Haweswater Aqueduct Resilience Programme, Marl Hill Section

**Ecology Comments on Planning Application 3/2021/0661
(Ribble Valley Borough Council)**

**John Jones
Senior Ecologist
Design & Construction Service
Lancashire County Council**

28th September 2021

FIGURE 6.5

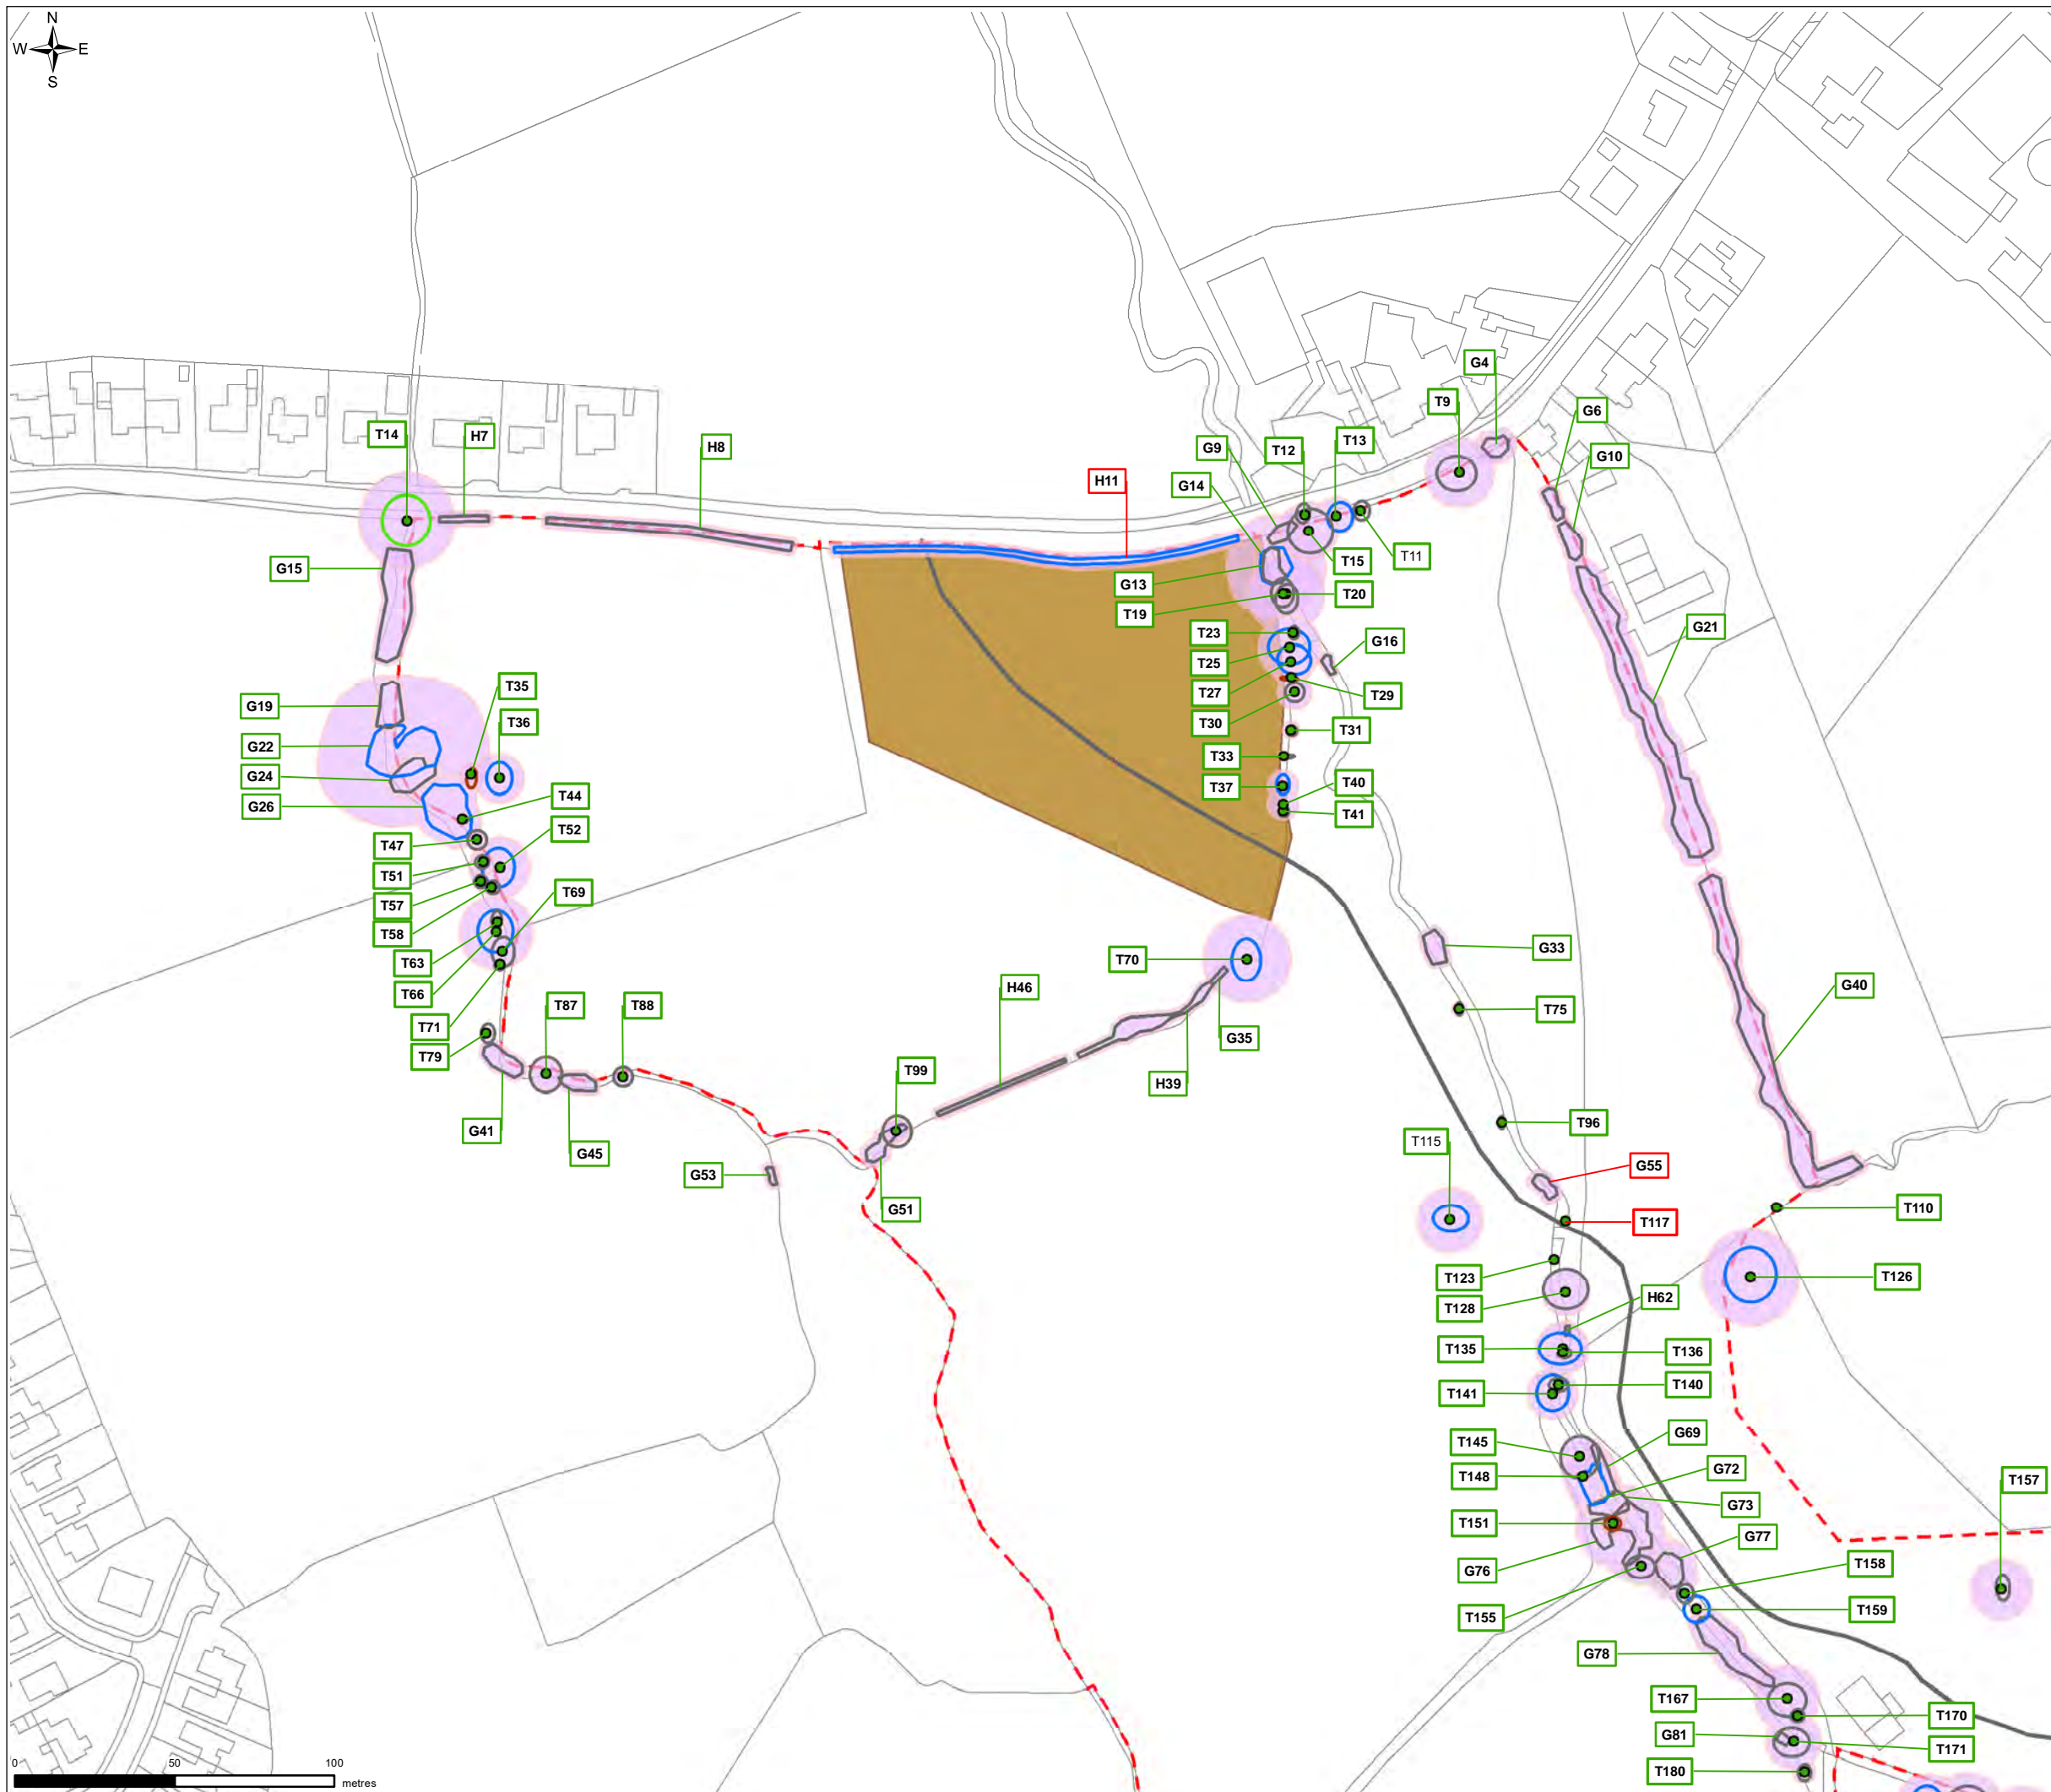
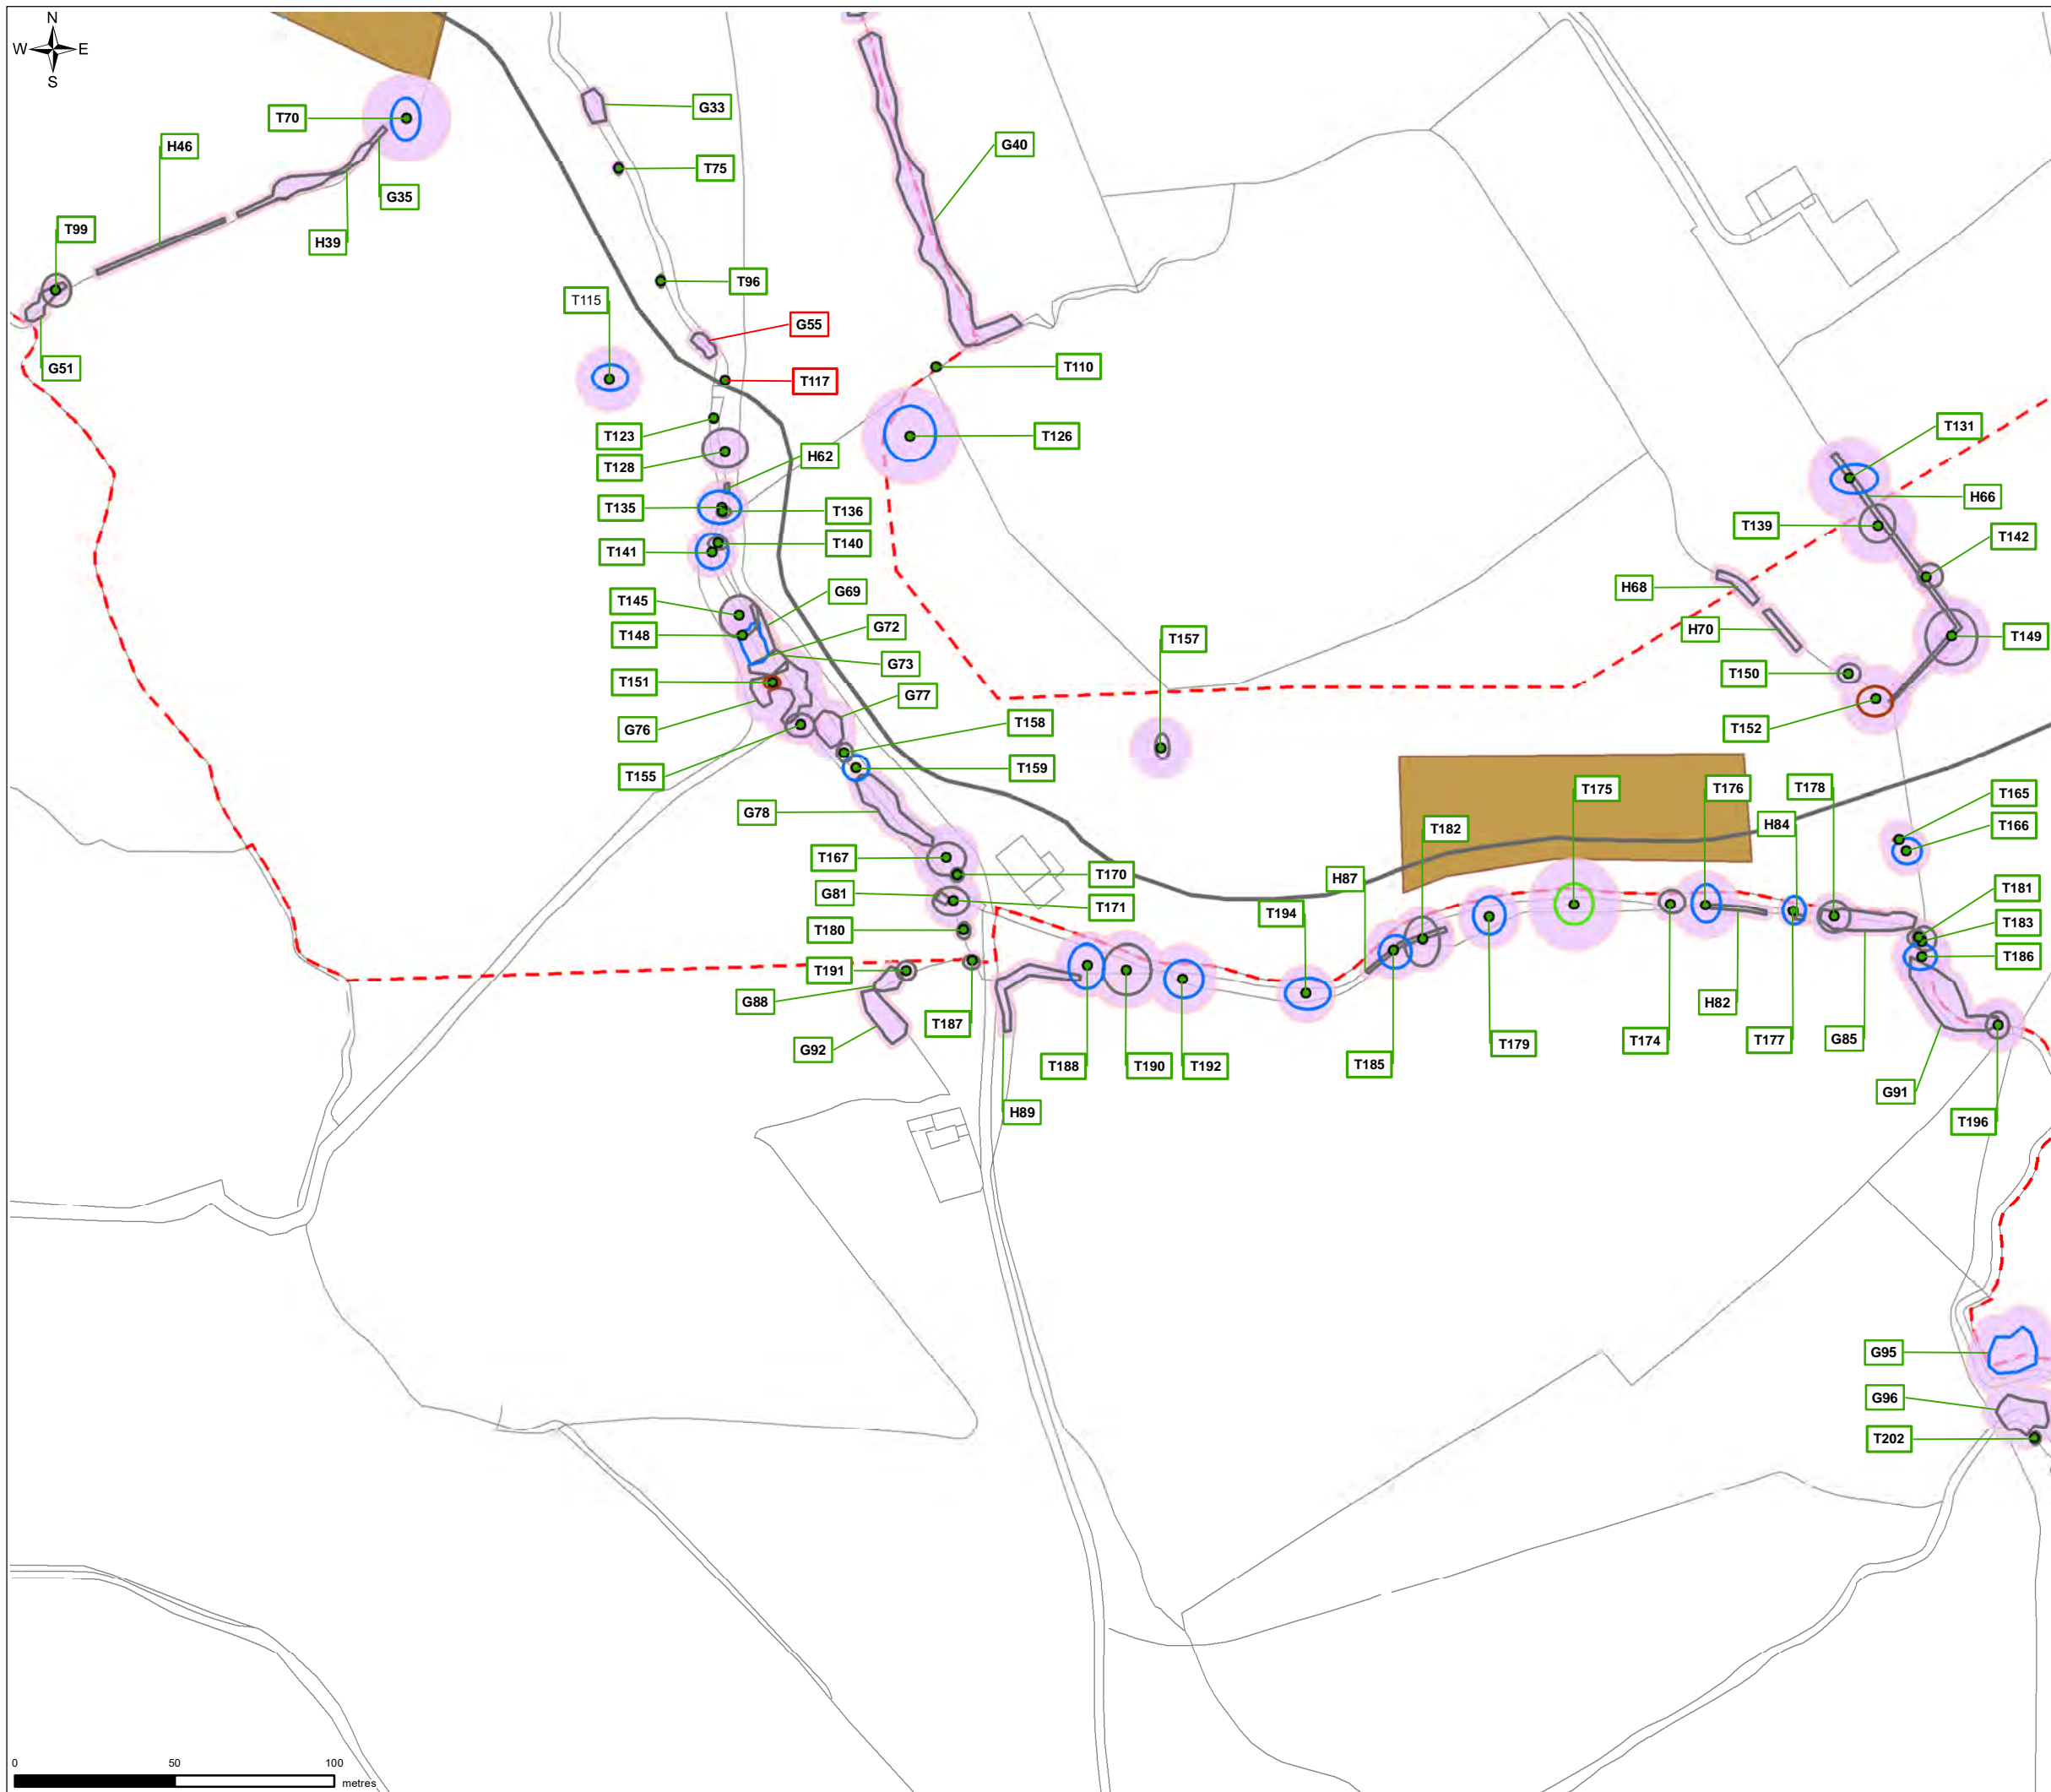
Conflicting information appears to have been submitted regarding the presence of features with the potential to support roosting bats, that may be affected by the proposed Ribble crossing and haul road. ES Vol 6 (Proposed Ribble Crossing) Chapter 9A (Terrestrial Ecology) and the associated Appendix, make the following apparently conflicting statements:

- Vol 6 Chapter 9A, Table 9A.7 – *"There are no trees with high, moderate or low bat roost suitability present within the construction route for the temporary haul road"*.
- Vol 6 Chapter 9A, Table 9A.4 *"Several trees with bat roosting potential are present within the Proposed Ribble Crossing"*
- Vol 6 Chapter 9A, Section 9.7.4 Para 76 – *"Suitable bat roost habitat features have been identified in numerous trees within and adjacent to the proposed Ribble crossing, some of which would require removal during the enabling and construction works phases"*.
- Vol 6 Appendix 9A.3: Bats, Section 3.1 Para 8 – *"Mature Trees are peppered across the site with various levels of suitability for roosting bats"*.

The above matter will need to be clarified/resolved prior to determination of the application to enable the planning authority to meet its statutory obligations. Notwithstanding the above, ES Vol 6, Proposed Ribble Crossing,

Chapter 9A: Terrestrial Ecology does acknowledge the presence of numerous trees with the potential to support roosting bats, in the area surrounding the proposed crossing and haul road. Section 9.6, Paragraph 58 (Effects carried forward for assessment) acknowledges that bats roosting in trees would be at risk from vegetation removal and ground works if present. The need for a Natural England licence will therefore need to be established through presence/absence surveys for bats and necessary licensing tests addressed as required before determination of the application (see statutory obligations below). All supporting survey data will need to be submitted, including a plan showing the location of all trees, buildings, structures and other features with the potential to support roosting bats and those that support roosting bats as well as sufficient information to address the licensing tests.
